**Notice of Exhibition
Eastern Creek Business Hub – Retail Component, Rooty Hill
(SSD 5175 MOD 3 and SSD 8588)**

Thank you for your letter dated 6 October 2017 requesting Transport for NSW (TfNSW) comment on the subject Concept Plan Modification and Stage 1 Project Application.

drawing title PROPOSED SITE PLAN -  
STAGE 1

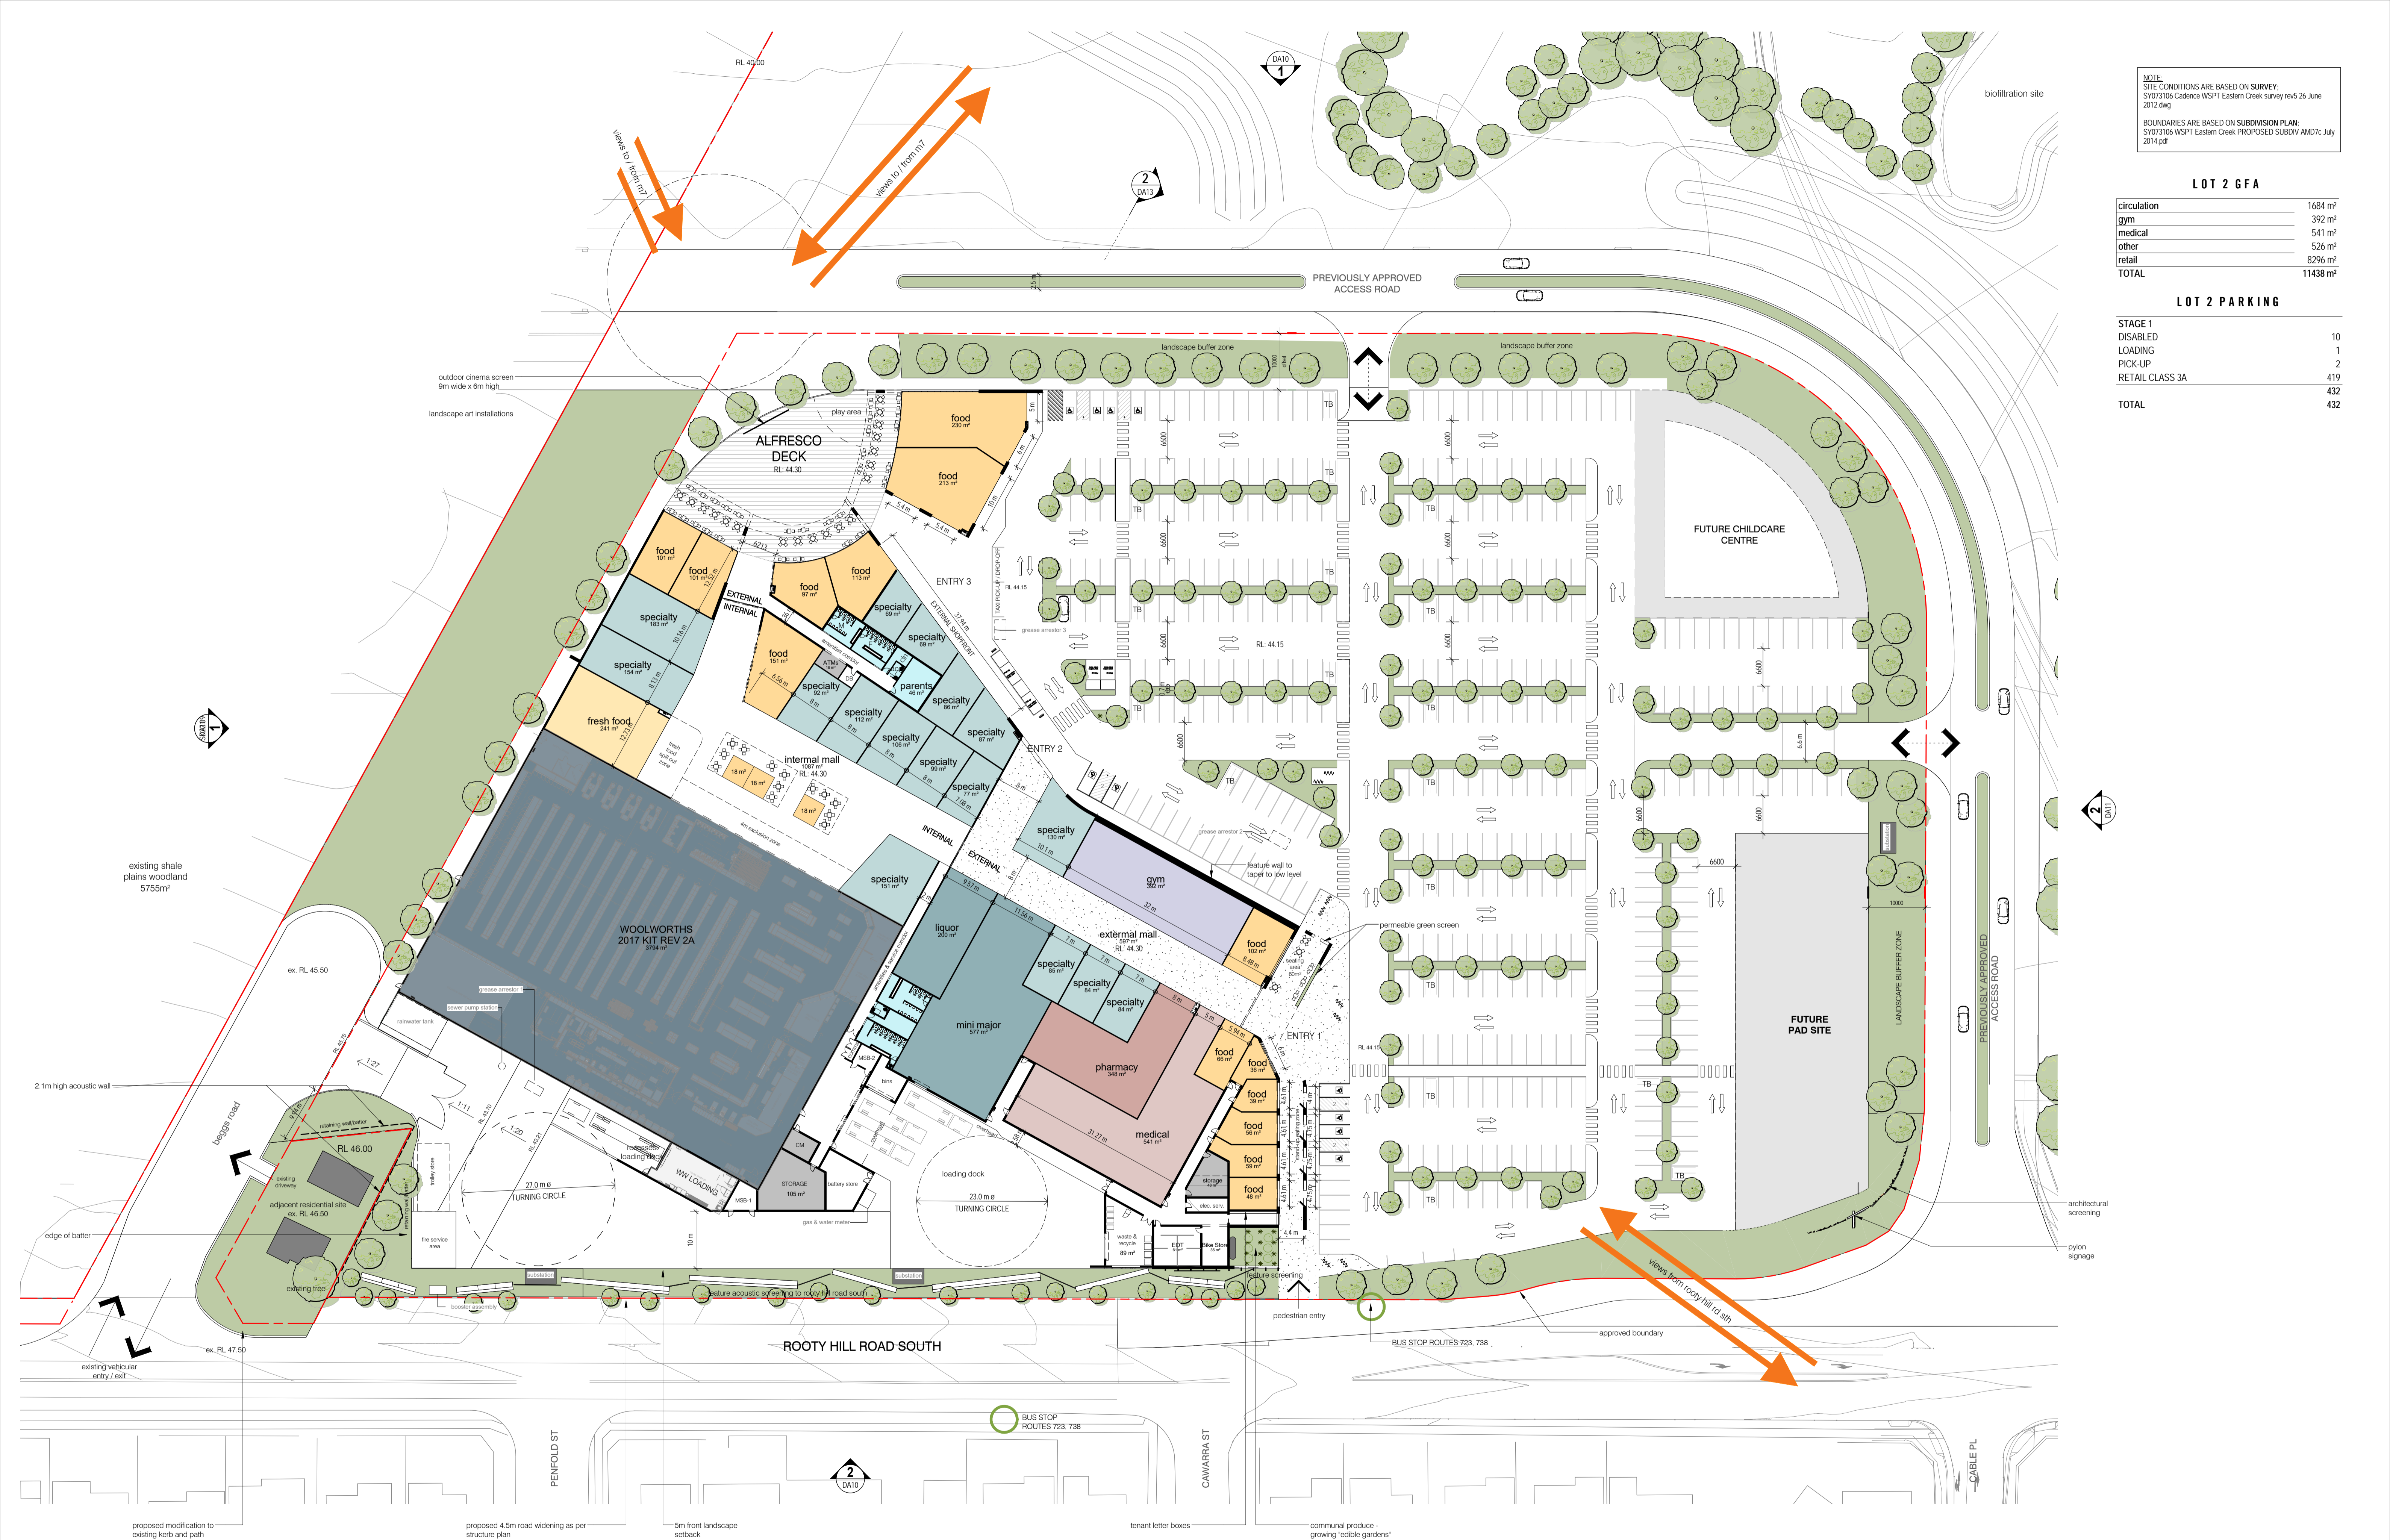
- Based on the site plans, the proposed signalised intersection at Rooty Hill Road South with Cable Place will impact the bus stop opposite Cawarra Street. It is understood that the detailed design of the intersection would likely be undertaken at the post-approval stage of development and in accordance with Roads and Maritime requirements. The design of the intersection should make provisions for, but not limited to:

- Potential relocation of the existing bus stop (TSN: 276618) on the eastern side of Rooty Hill Road South to ensure relevant road safety and bus design requirements are satisfied; and

- Adequate provision of footpaths and pedestrian connectivity (in accordance with accessibility standards) within the road reserve between both bus stops in proximity to Cawarra Street and the proposed pedestrian entry.
